**City of Portland, Maine - Building or Use Permit Application**

Location of Construction: 9 HUNT ST	Owner Name: WOODFORD HIGHLAND LLC	Owner Address: 104 GRANT ST	Phone:
Business Name:	Contractor Name: Mark Tardiff	Contractor Address: 10 Wolcott Street Portland	Phone: 2072399046
Lessee/Buyer's Name	Phone:	Permit Type: Alterations - Multi Family	Zone: R-5

Proposed Use: Ten (10) family residential -unit building - remove current front entry and roof system and replace w/ new. Entry will be same size	Proposed Project Description: remove current front entry and roof system and replace w/ new. Entry will be same size
--	---

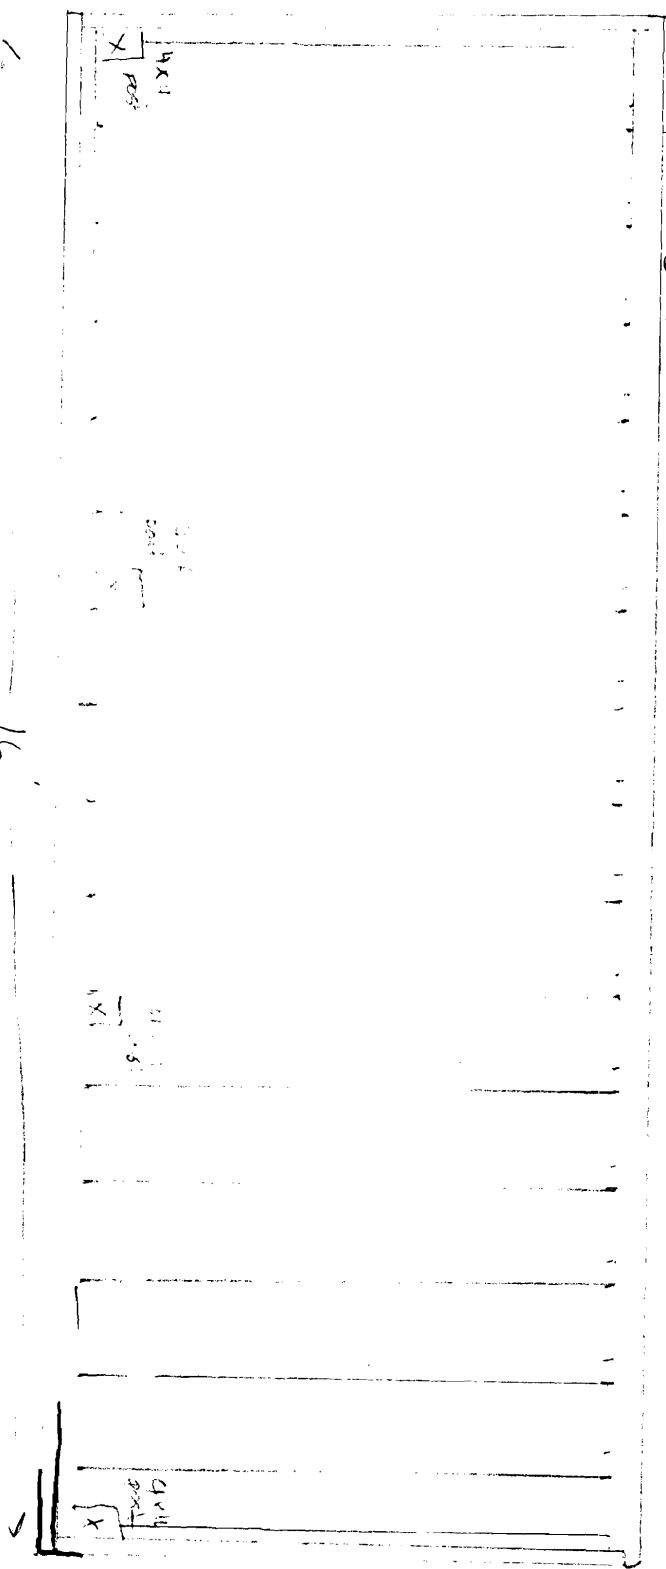
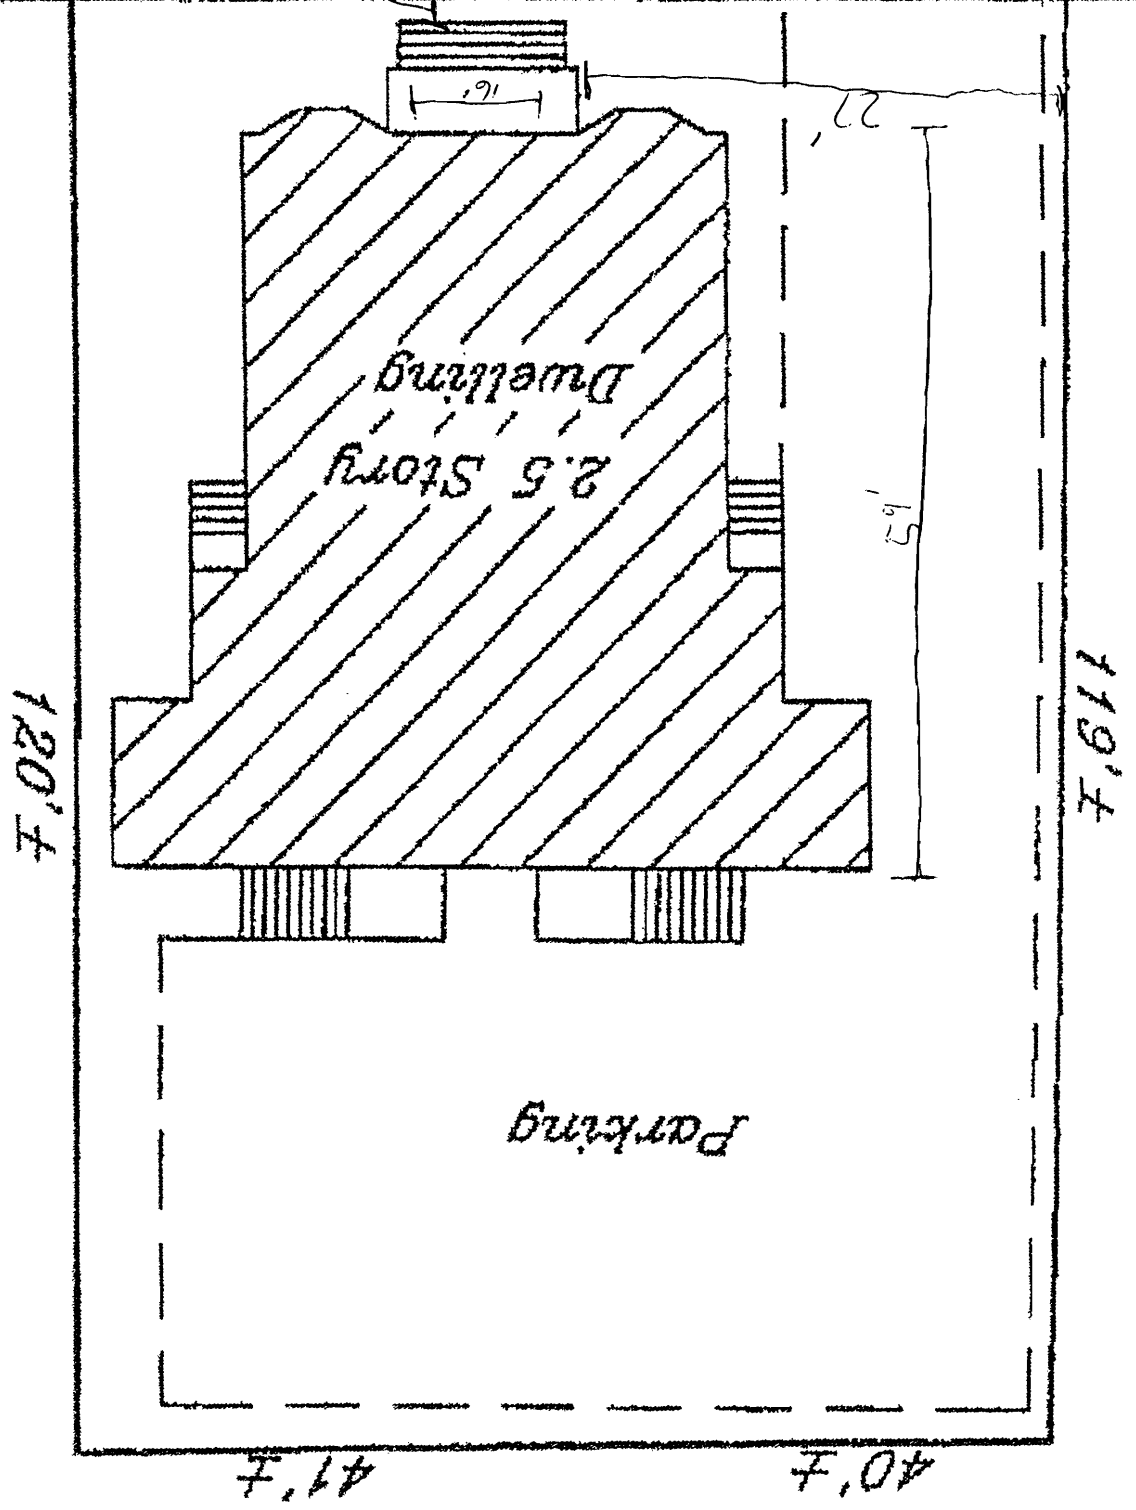
<b>Dept:</b> Building	<b>Status:</b> Approved with Conditions	<b>Reviewer:</b> Tom Markley	<b>Approval Date:</b> 10/24/2008
<b>Note:</b>			<b>Ok to Issue:</b> <input checked="" type="checkbox"/>
<ol style="list-style-type: none"> <li>1) Guards must be 42 inches in height with openings less than 4 inches. Graspable rails must be installed on both sides of the stair guard. Stair treads shall not be less than 11". Stair risers shall not be more than 7".</li> <li>2) Application approval based upon information provided by applicant. Any deviation from approved plans requires separate review and approval prior to work.</li> </ol>
